Discovery Point Stage 1 Mixed Use Development - Response to Submissions

Project Application (MP 10_0030)

1. Discovery Place (West) Paving Finishes

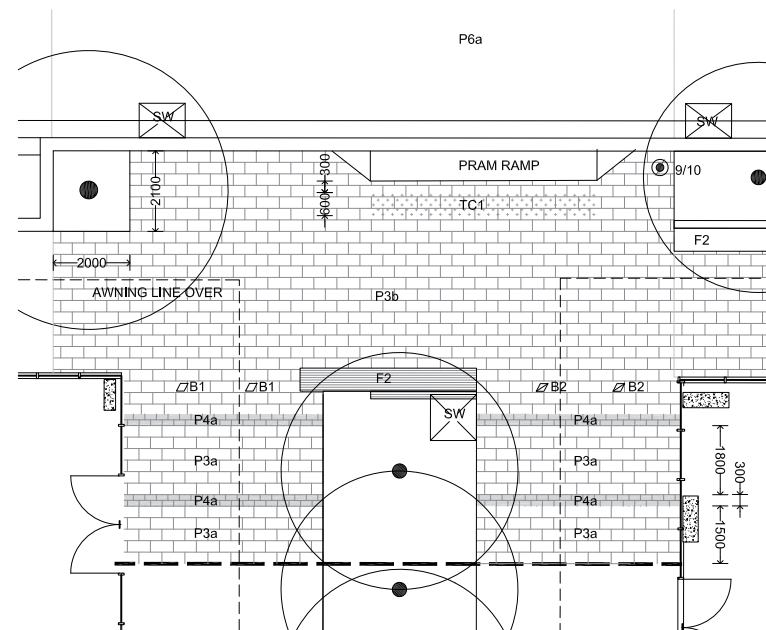
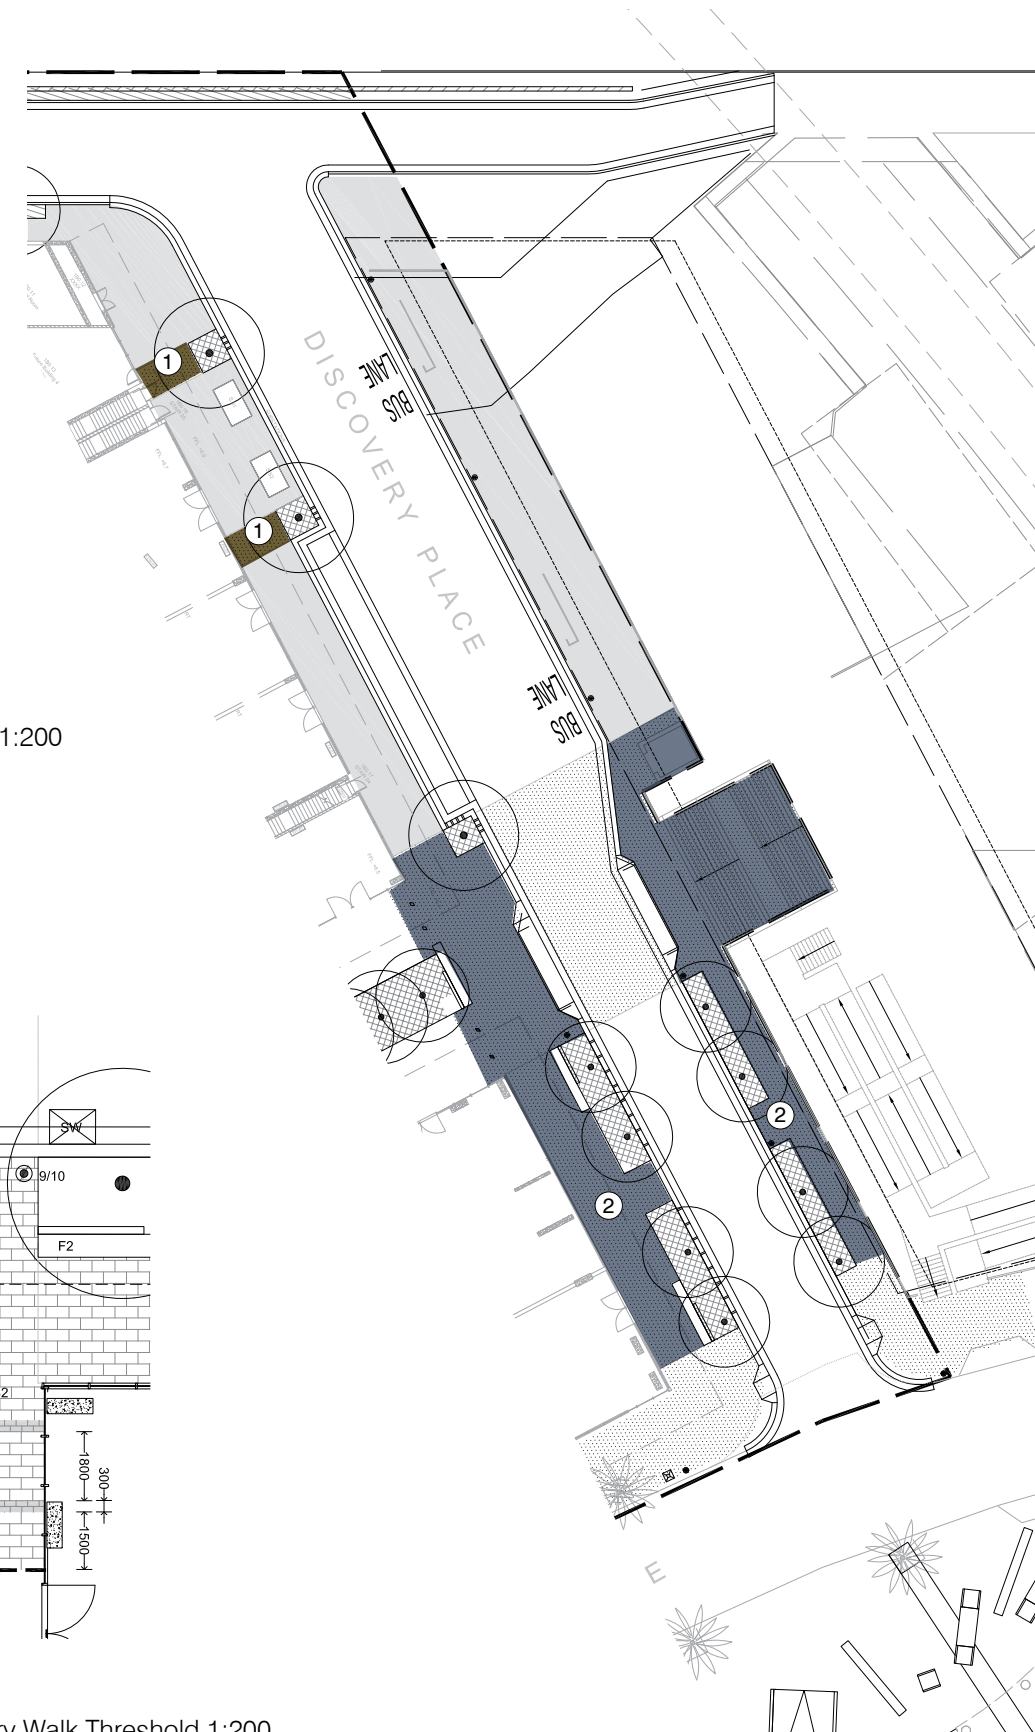
3.	The Concept Plan Approval states that all future development should be generally consistent with the Rockdale City Council's Wolli Creek and Bonar Street Public Domain Plan and Technical Manual. It is requested that further details be submitted demonstrating that the proposal is generally consistent with the Public Domain Plan and Technical Manual in consultation with Council. Noted. Correspondence is to be provided to Council for endorsement outlining and justifying where variations to the Wolli Creek and Bonar Street Public Domain Plan and Technical Manual are proposed. A draft of the justification statement, prepared by Turf Design Studios, is provided for information purposes at Appendix D. In summary, despite the variations, the proposal is generally consistent with the Public Domain Plan and Technical Manual.

10.	Proposed landscaping and public domain works are to conform with the Wolli Creek and Bonar Precinct Public Domain Plan (PDP), particularly the Technical Manual as required by several conditions of the Masterplan consent. The email (Appendix S) does not constitute an agreement to modify the PDP.	Noted. Correspondence is to be provided to Council for endorsement outlining and justifying where variations to the Wolli Creek and Bonar Street Public Domain Plan and Technical Manual are proposed. A draft of the justification statement, prepared by Turf Design Studios, is provided for information purposes at Appendix D . In summary, despite the variations, the proposal is generally consistent with the Public Domain Plan and Technical Manual.

Diagram 5.2 - Building separation

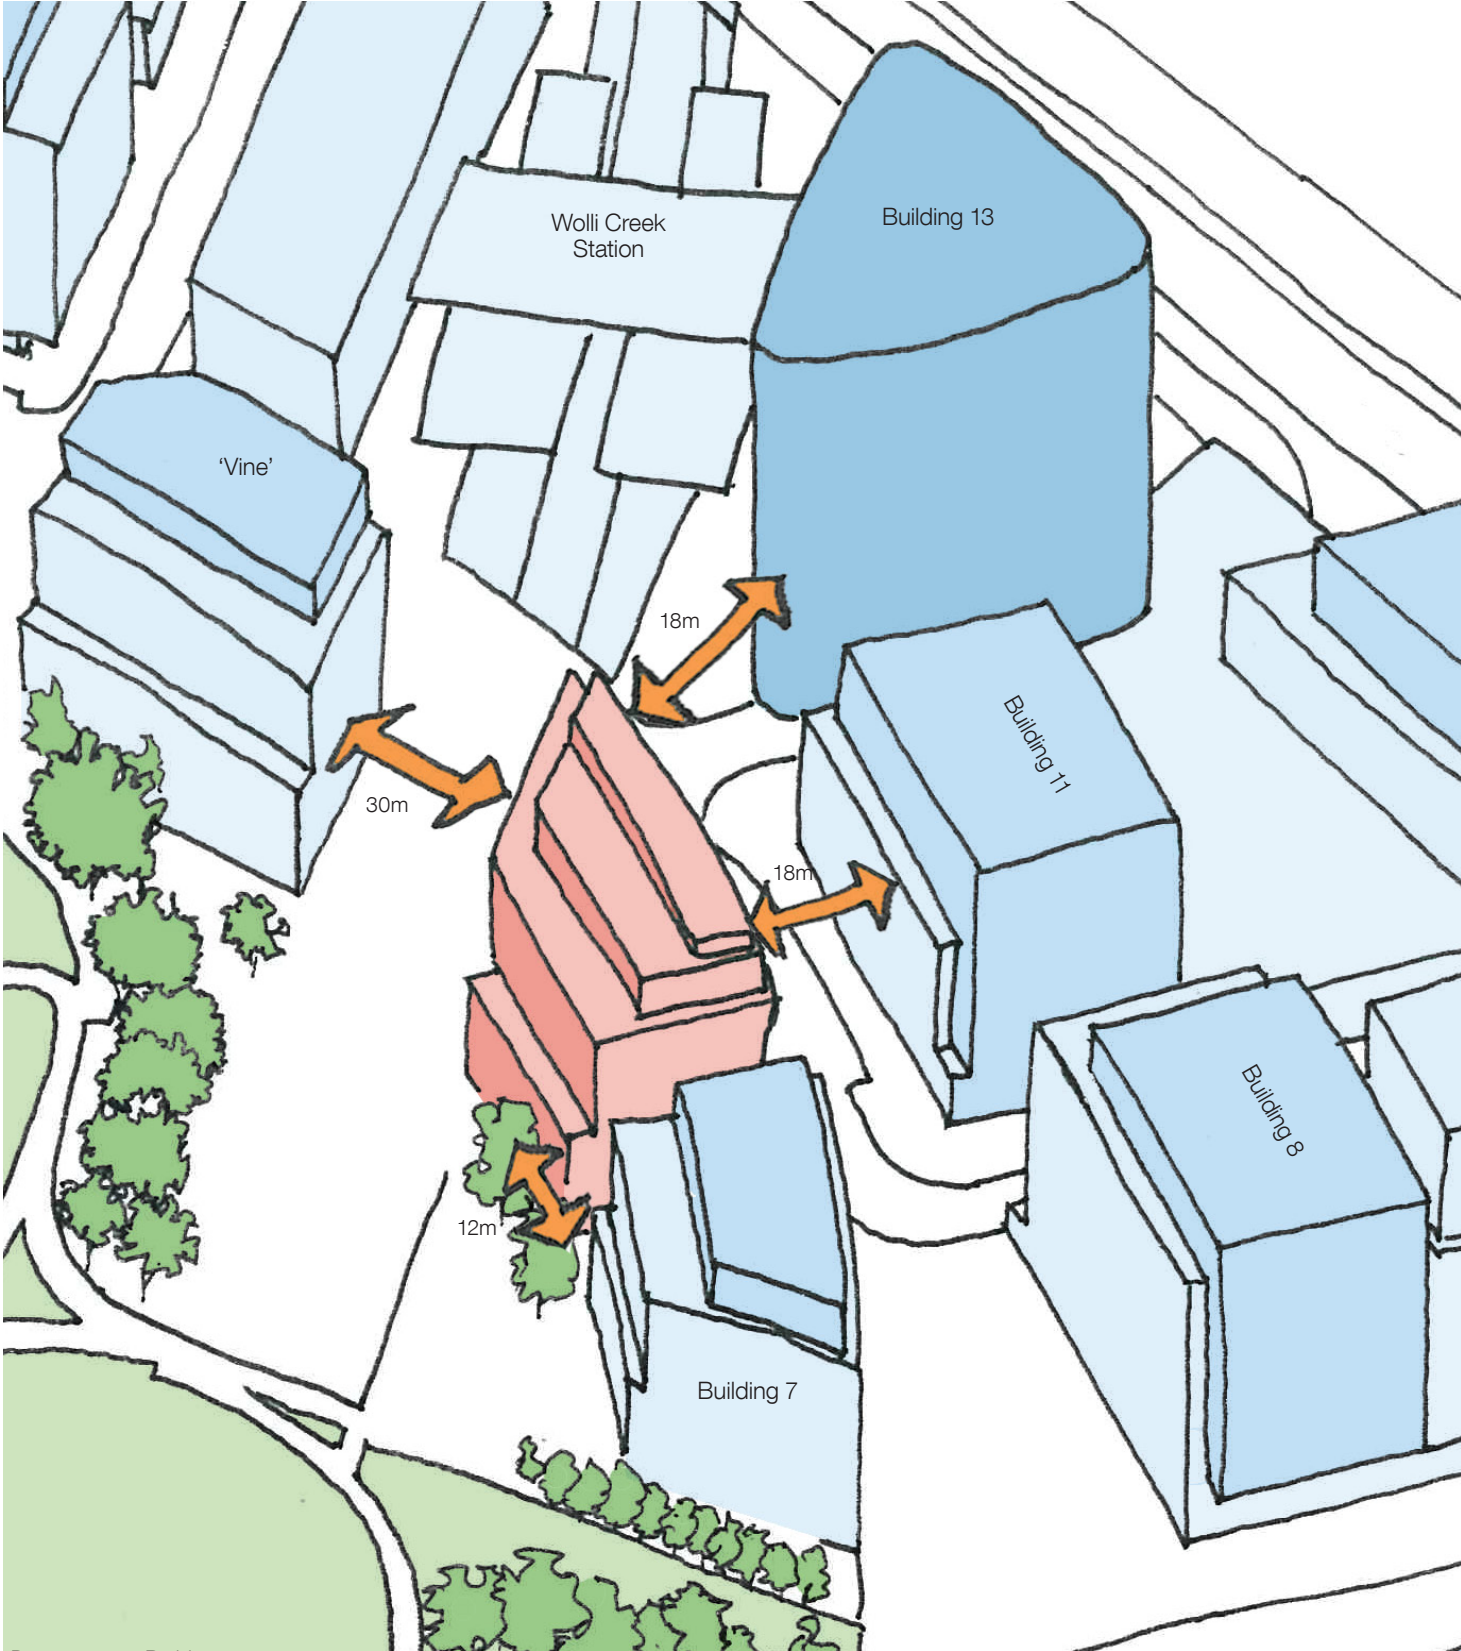
Issues Raised		Proponent Response
5.	Further clarification is requested to demonstrate compliance with the Concept Plan Approval. Specifically it is requested that: ▪ further details and plans be submitted to demonstrate that the development will result in a building separation along the length of Discovery Point Place of a minimum of 16 metres (not including colonnades) in accordance with Modification B1 of the Concept Plan Approval; ▪ dimensions of balconies be indicated on the plans to ensure compliance with Requirement A10 of the Concept Plan Approval; and ▪ clarification be provided that the Development Design Guidelines have been amended to address plant rooms and lift overruns on the roof being appropriately screened and not to exceed approved heights as required by Modification B3 (h) of the Concept Plan Approval.	Noted. Plans have been amended accordingly (refer to Appendix G) and demonstrate: • The building separation along Discovery Point Place achieves a minimum of 16m in accordance with the conditions of the Concept Plan Approval. • The area and dimensions of all balconies comply with the Concept Plan Approval – i.e. minimum depth of 2m and minimum width of 2m. Studios and one bedroom dwellings provided with a minimum area of 6m², 8m² for two bedroom dwellings and 10m² for three bedroom dwellings. The Development Design Guidelines have also been amended accordingly to include the control that plant rooms and lift overruns on the roof are to be appropriately screened and not to exceed approved building heights. The amended Development Design Guidelines are included at Appendix K.

2 Temporary Bus Stop  
DA3.100 1 : 100

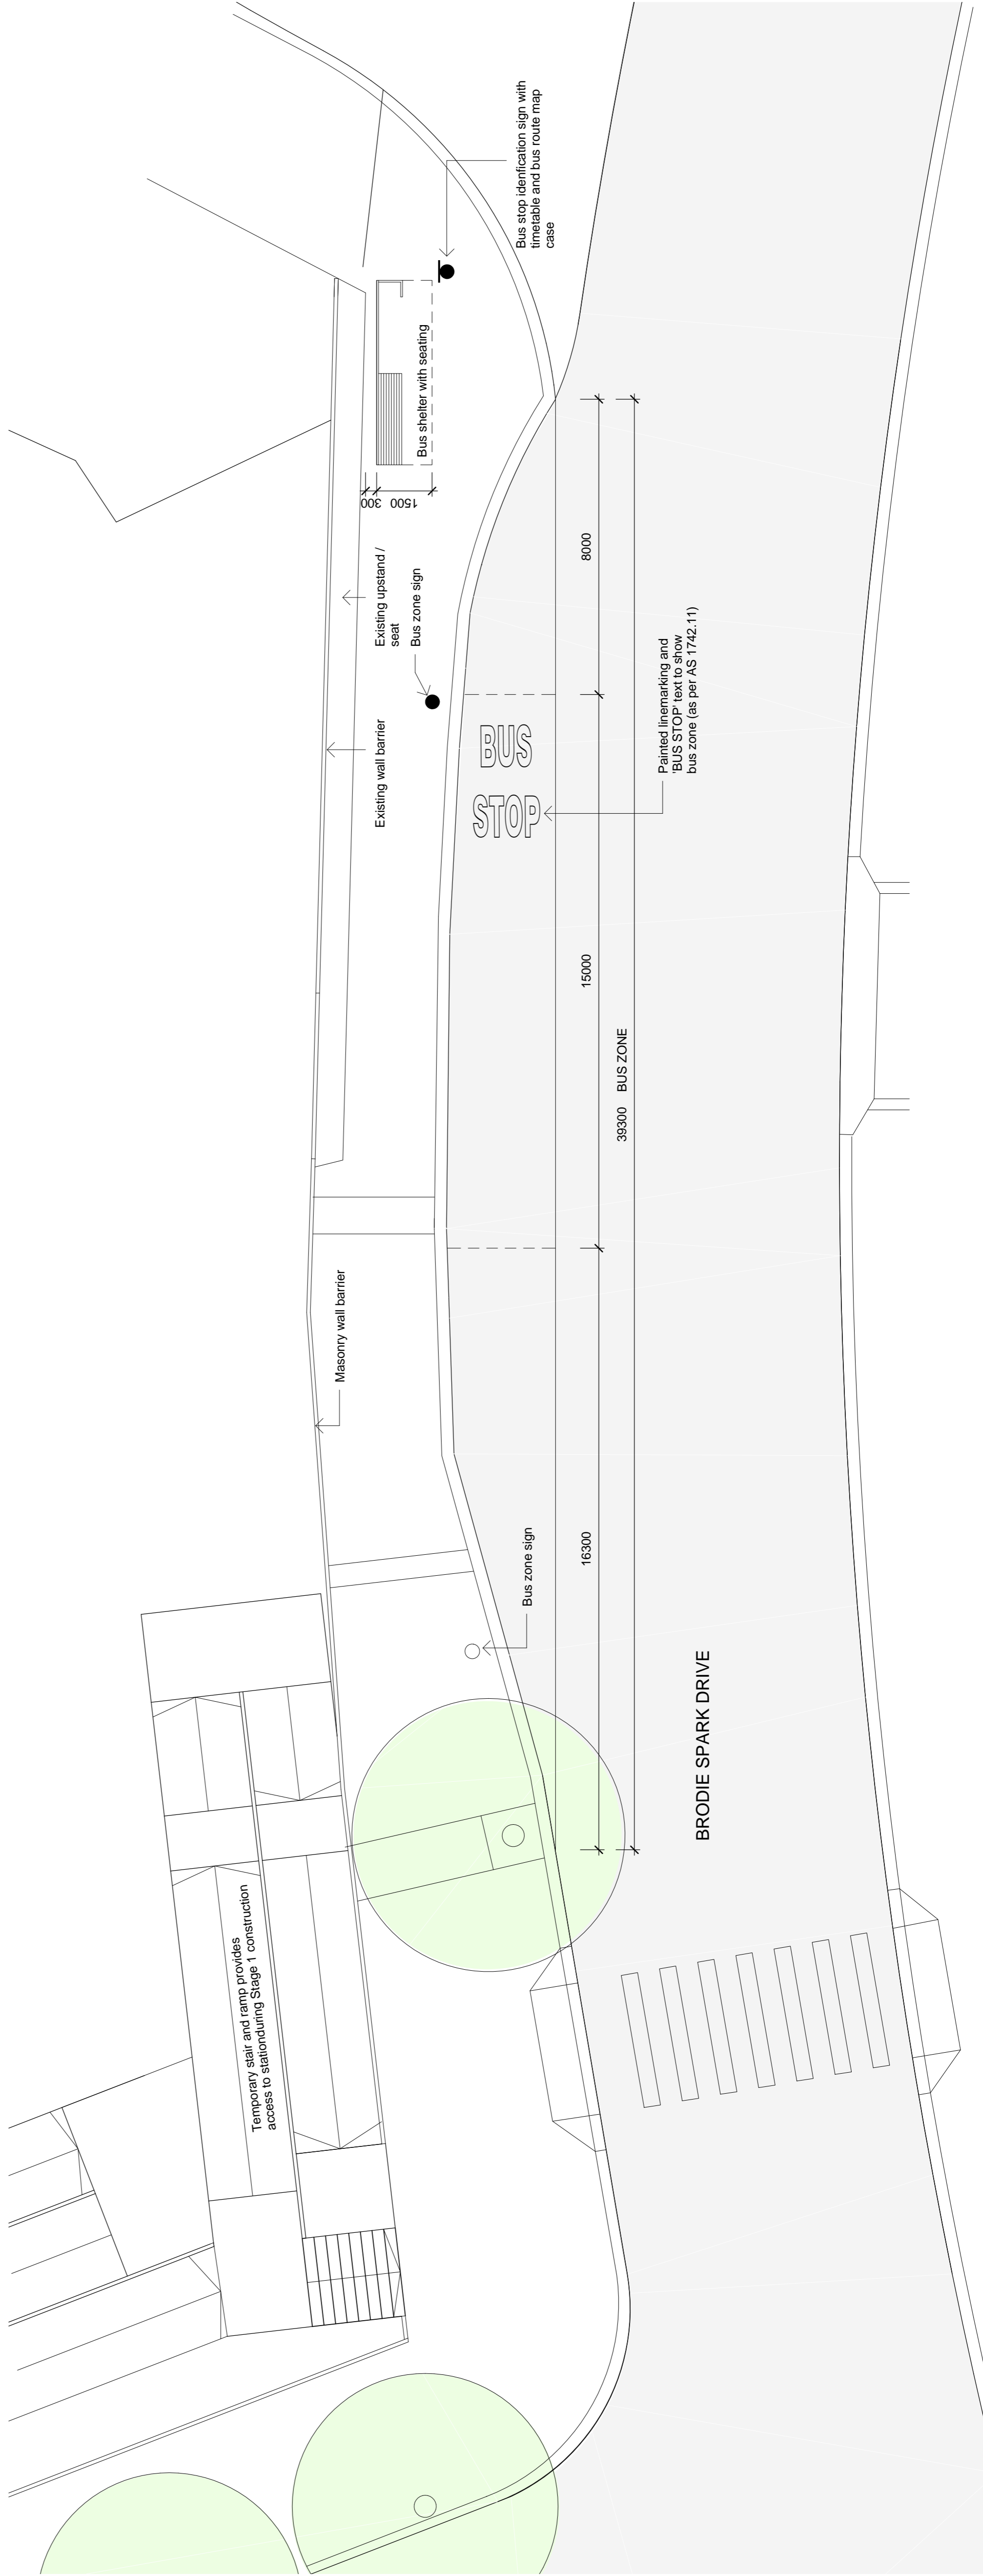
28.	An additional temporary bus stop may be needed along the western kerb in Brodie Spark Drive to the south of Discovery Point Place.	The design of the temporary bus zone provision has been developed in consultation with STA. In this regard, the STA has no objections to the proposed temporary arrangements and the final bus zone arrangements (refer to Appendix C).

## SWEPT PATH ANALYSIS OF A 12.5m RIGID VEHICLE

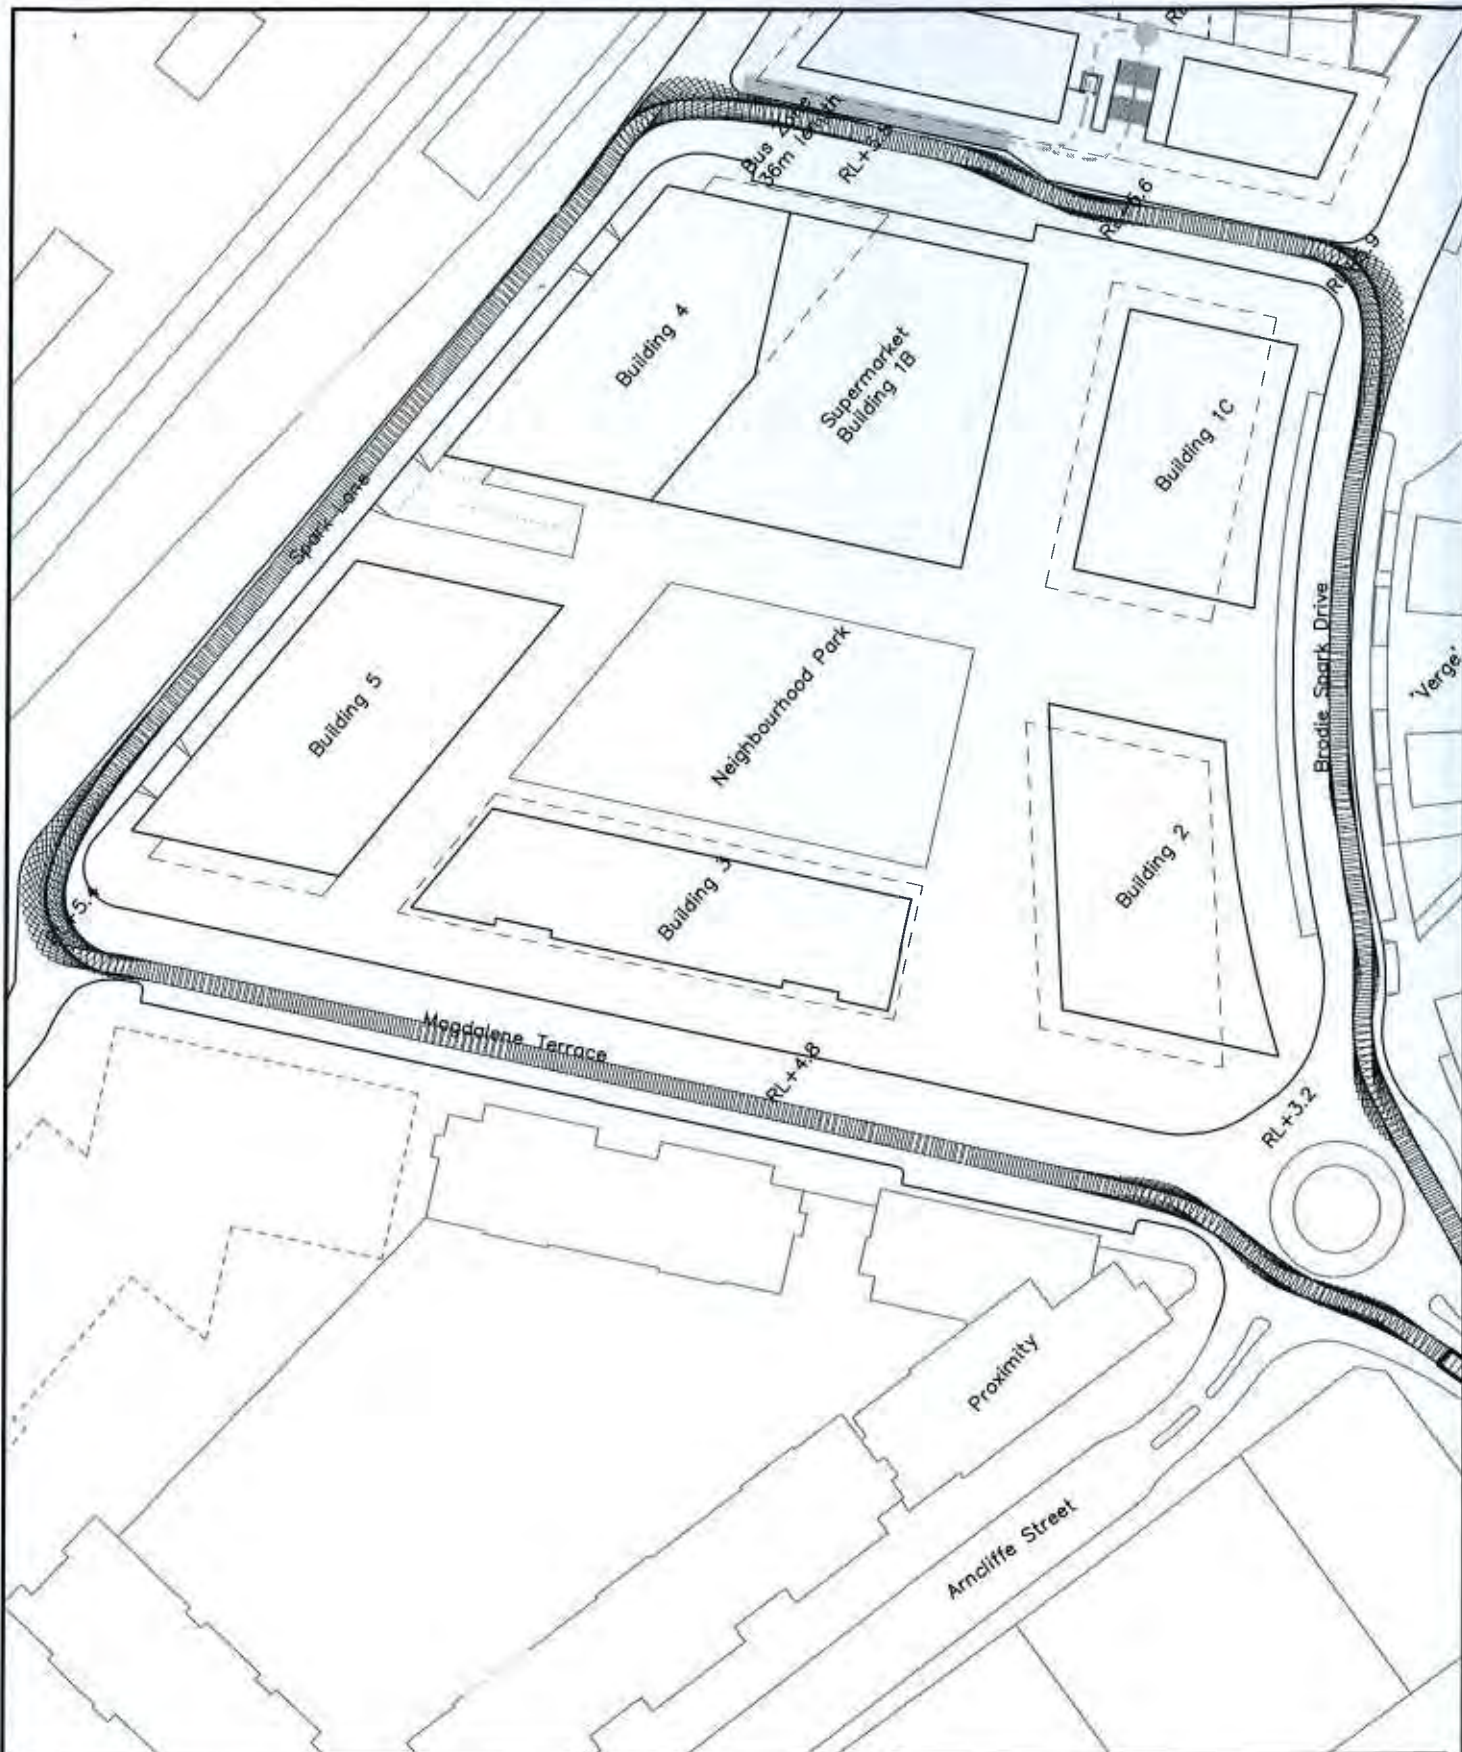
23.	Consideration to given to accommodating 12.5 metre long vehicles in the loading dock rather than only an 8.8 metre vehicles.	Accommodating a 12.5m long vehicle is not possible, nor desired by retail tenants. Turning paths are designed for 10.2m truck. There is no requirement for a 12.5m truck with the relatively small retail elements.
